An
Bord
Pleanála

Inspector's Report ABP-320327-24

Whether or not: (a) Structure No. 1: Gate Lodge A and Gate Lodge B; (b) Structure No. 2: semi-detached agricultural storage facility; (c) Structure No. 3: detached agricultural maintenance/storage facility; (d) Structure No. 4: electricity distribution building; (e) Structure No. 5: open fronted agricultural storage shed; (f) Structure No. 6: former agricultural building, now used to accommodate protected persons; (g) Structure No. 7 and Structure No. 8: pavillion and kitchen building; (h) Structure No. 10: former Belfry Building; (i) Structure No. 11: concrete paved area adjacent to structure no. 10 and 12; (j) Structure No. 12: accommodation block no. 1; (k) Structure No. 13: Art O'Neills building; (l) Structure No. 14: car park adjacent to the former Belfry Building; (m) Structure No. 15: large gravelled area to the north east of the holiday village; (n) Structure No. 16: accommodation block no. 2 and (o)

Kippure Lodge and Holiday Village,
Kippure Estate, Manor Kilbride,
Blessington, County Wicklow.

Drawing file: 320327 Referral / PL-16-01-KE Structure 16.pdf

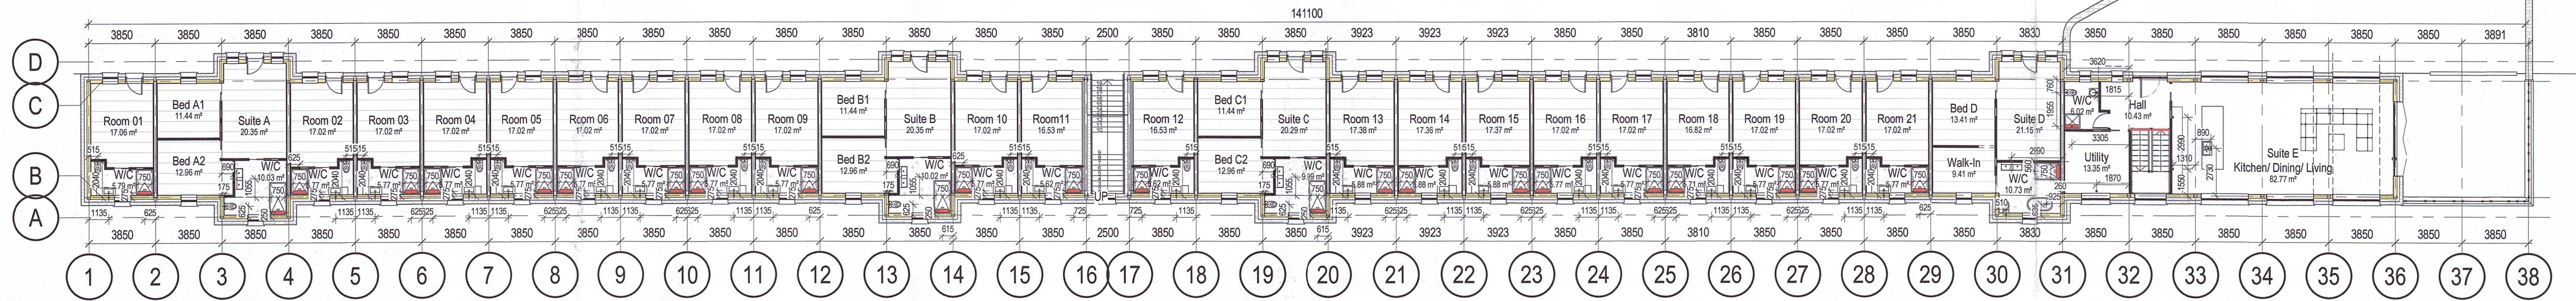
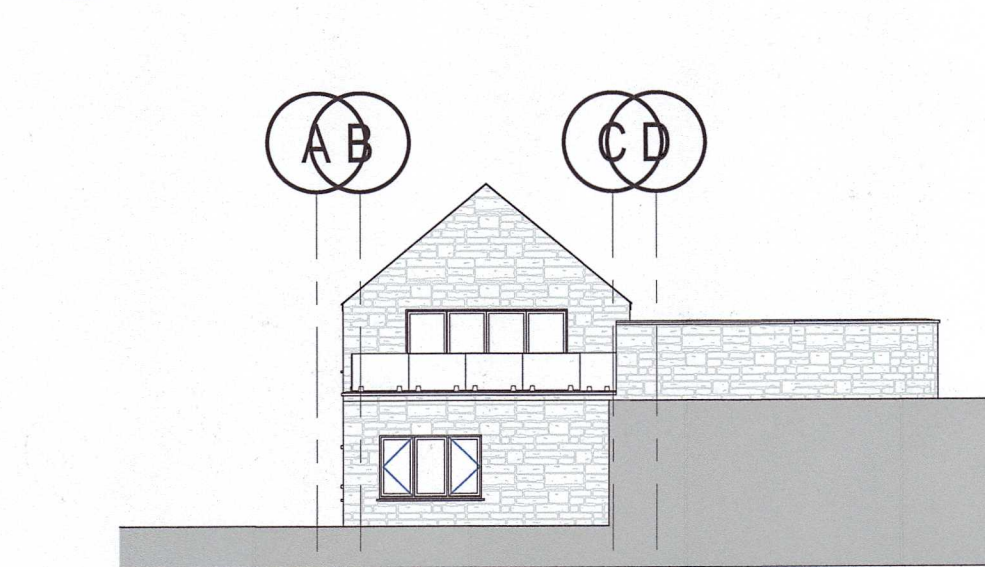
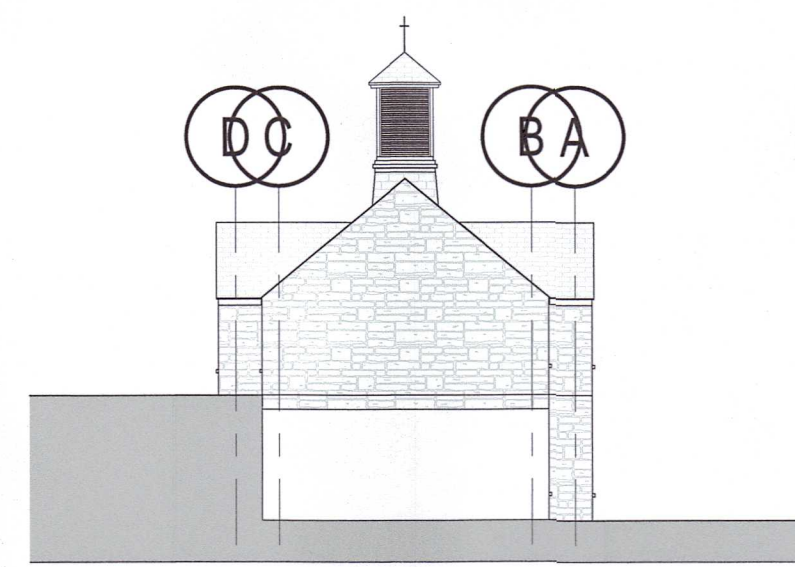
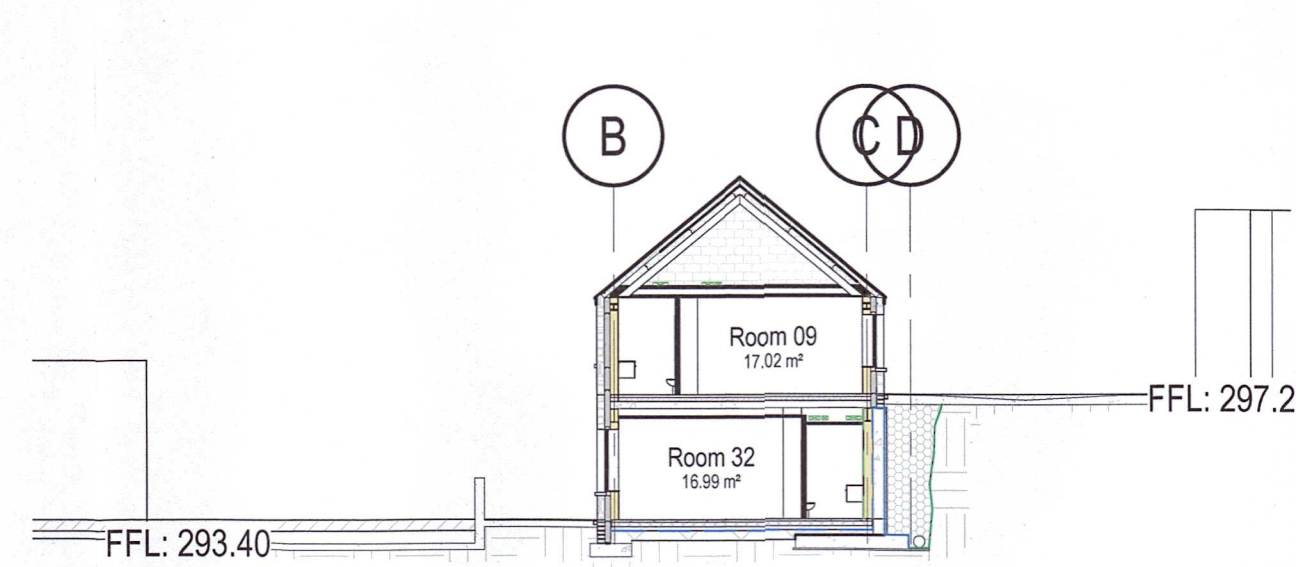
Information submitted with Reg. Ref. 12/6539 indicates that the 'existing shed' was a minor structure being limited in scale. The information provided with the submission indicates that Structure 16 is a modular building, and its principal components were manufactured off site, with the building assembled on site and fixed with bolts to a pre-constructed reinforced concrete retaining wall.

Section 4(1)(h) is not applicable as Structure 16 is a new structure. There are no exemptions in the PDR that would apply to Structure No. 16.

Structure No. 16 is development and is not exempted development.

Drawing file: 320327 Referral / PL1081KE Structure No. 1 - Gate Lodge A.pdf

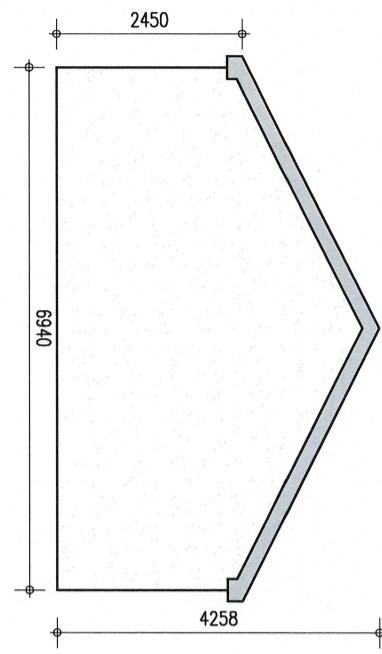
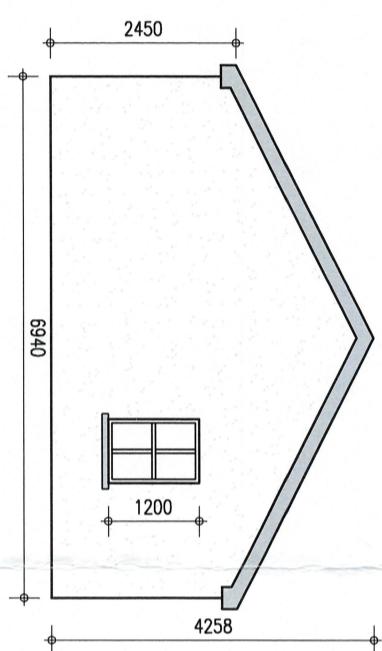
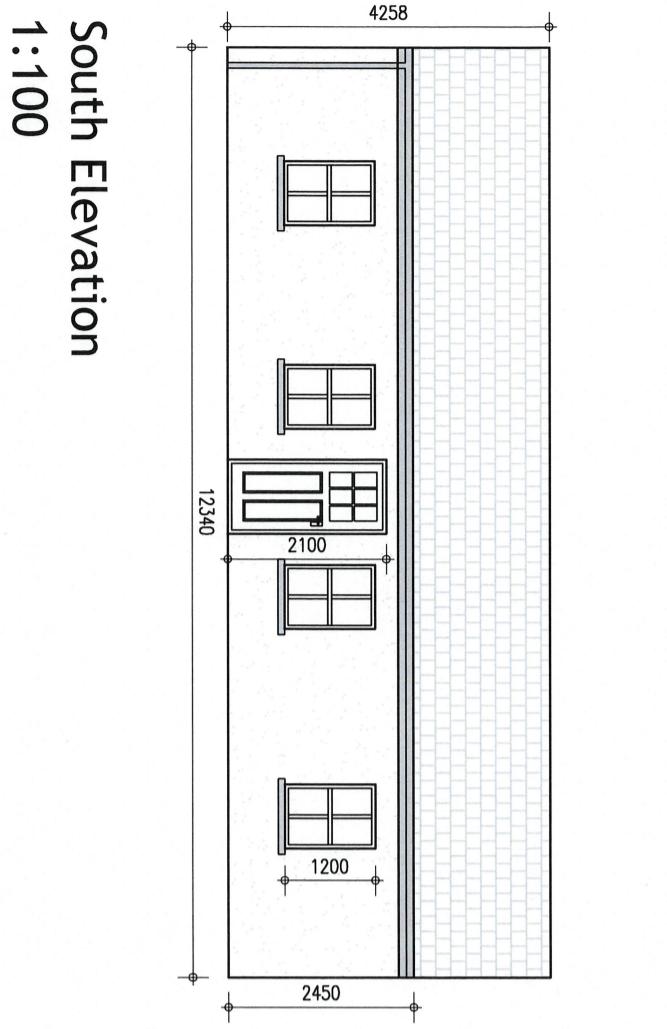
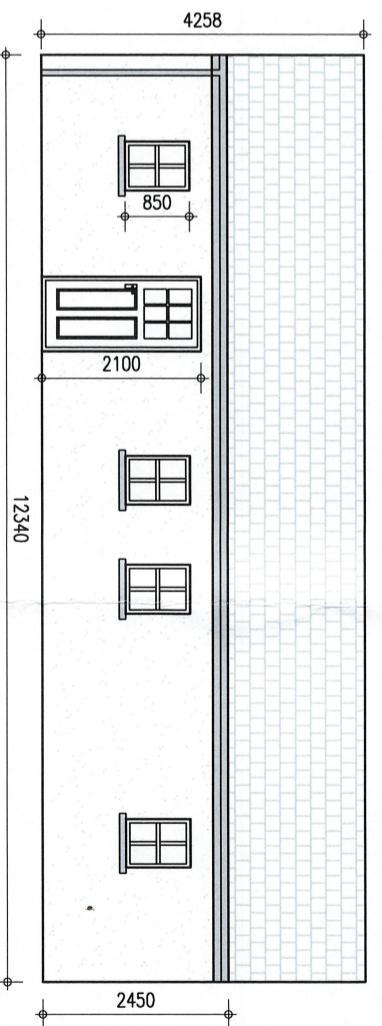
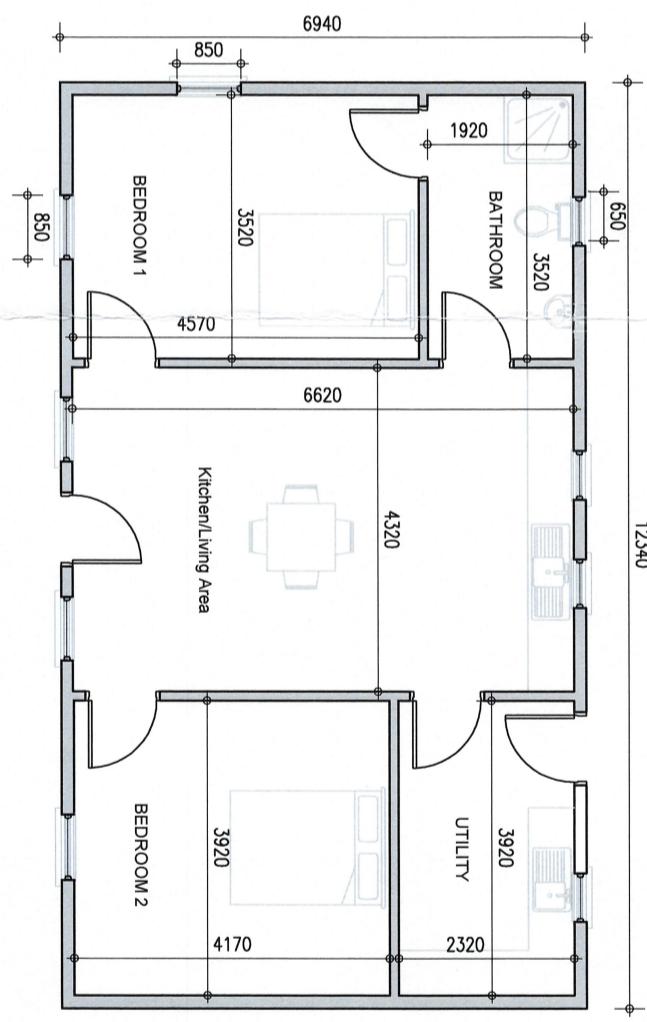
The construction of the gate lodge units would come within the meaning of works and would therefore come within the meaning of development as provided for in Section 3(1) of the PDA.

The provisions of Section 4(1)(h) are not applicable as these are new structures on the land.

The exemption under Class 17 of Part 1 of Schedule 2 is for on-site accommodation for persons who are engaged in the development. The lodges are not for security for the construction works, but security for those occupying the facility. It is not evident that the on-going development has the necessary permissions or exemption, and therefore these lodges do not come within the description of Class 17.

There are no other exemptions available. Therefore, these structures are development and are not exempted development.
